STATE OF NORTH CAROLINA
DEPARTMENT OF TRANSPORTATION

May 8, 2013

Subject: **Response to On Hold Letter** for request for Section 401 Water Quality Certification Modification, Wilmington Bypass from north of US 74/76 in Brunswick County to US 421 in New Hanover County. DWQ Project No. 10-0867v.4. TIP R-2633B.

Reference: NCDOT Modification Request, dated April 3, 2013
NCDWQ On Hold Letter, dated April 19, 2013, received April 26, 2013

PERMIT DRAWING
SHEET 6A OF 73
1/20/15

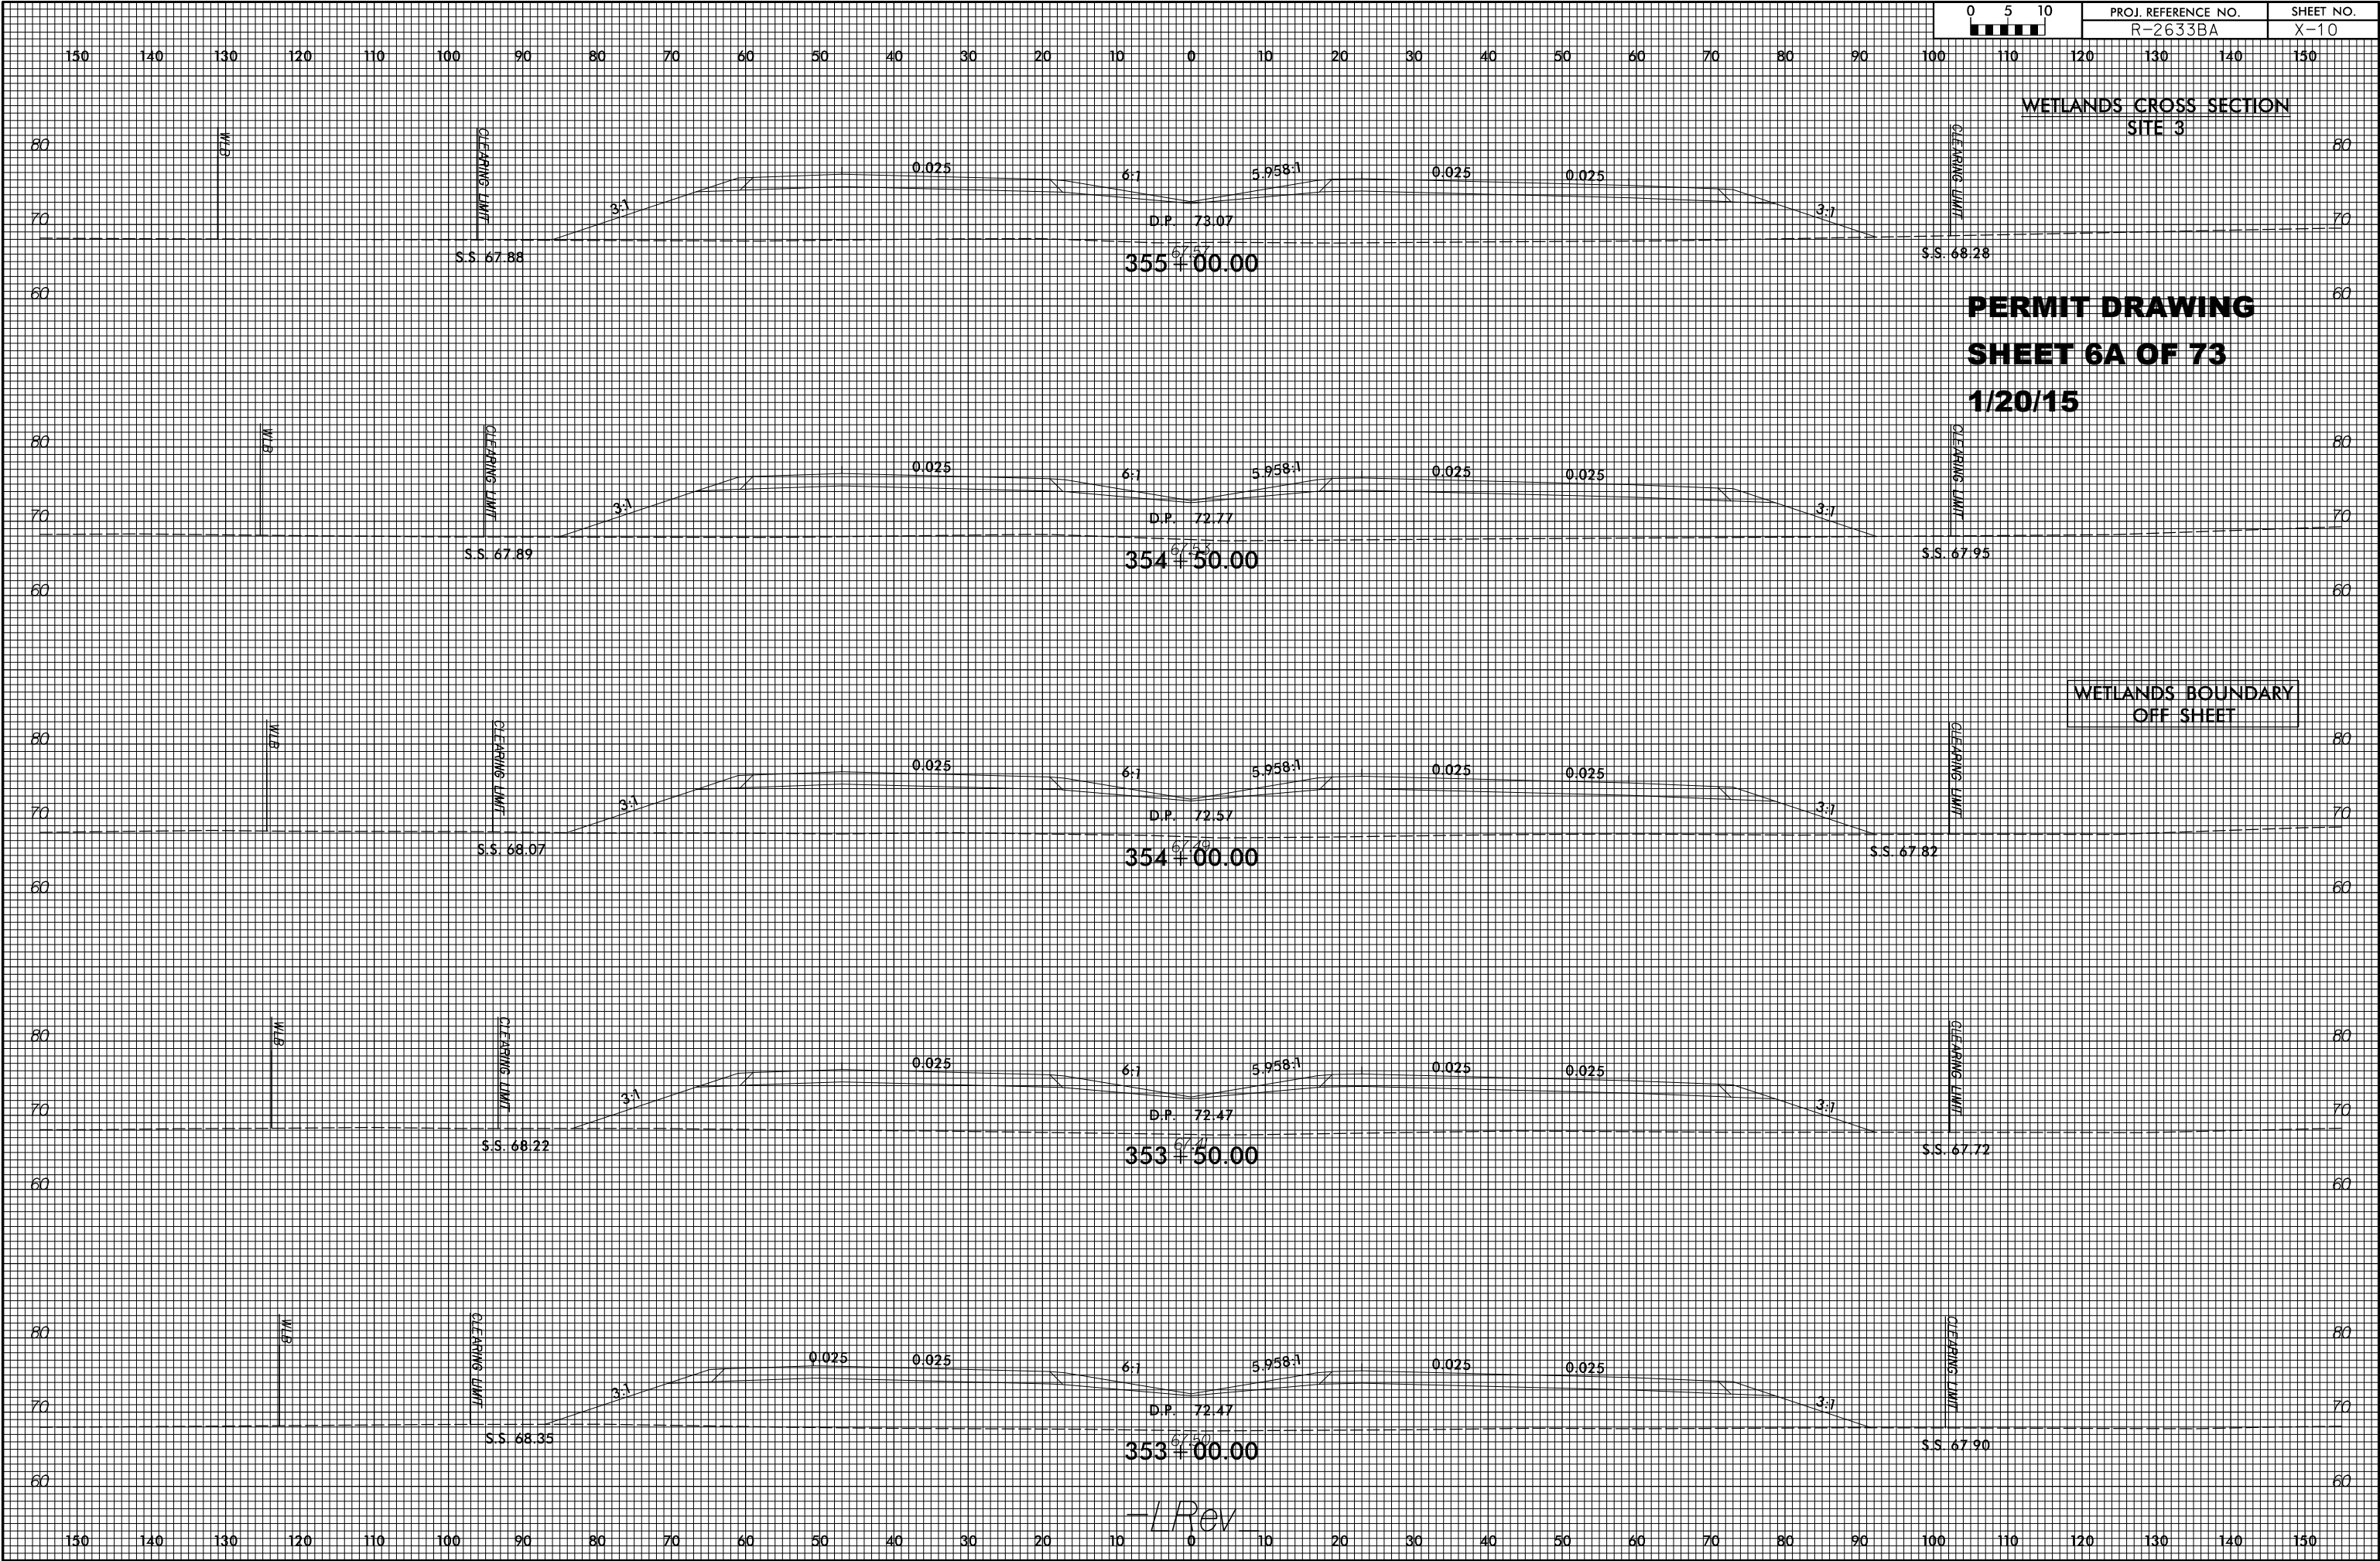
1. *Sites 3 & 5 – the cross section station numbers do not match the station numbers on the plan sheet. Also, the match line station numbers do not match the stations on the plan sheet. The station numbers in the impact summary and on the plan sheets run from 40+57 to 75+00 but the cross section numbers are listed as 345+00 to 375+00. Please change the cross section station and match line stations to coincide with the stations along the –L– line on the plan sheets.*

1. Sites 3 & 5 – the cross section station numbers do not match the station numbers on the plan sheet. Also, the match line station numbers do not coincide with the stations on the plan sheet. The station numbers in the impact summary and plan sheets run from Sta. 40+57 to 75+00 but the cross section numbers are listed as Sta. 345+00 to 375+00. Please change the cross section stations and match line stations to coincide with the stations along the -L- line on the plan sheets.

3. Your application states in the "Avoidance and Minimization" section that 3:1 slopes will be used in wetland areas to minimize wetland impacts. Upon review of the application there are several cross sections that show greater than 3:1 slopes. Please correct.

Sites 3, 5 & 6 permit drawings, cross sections, and impact summary sheet have been revised and are enclosed. As a result, proposed permanent fill has decreased at these sites by 1.42 acres. Additionally, we will submit a revised request to EEP for an updated acceptance letter.
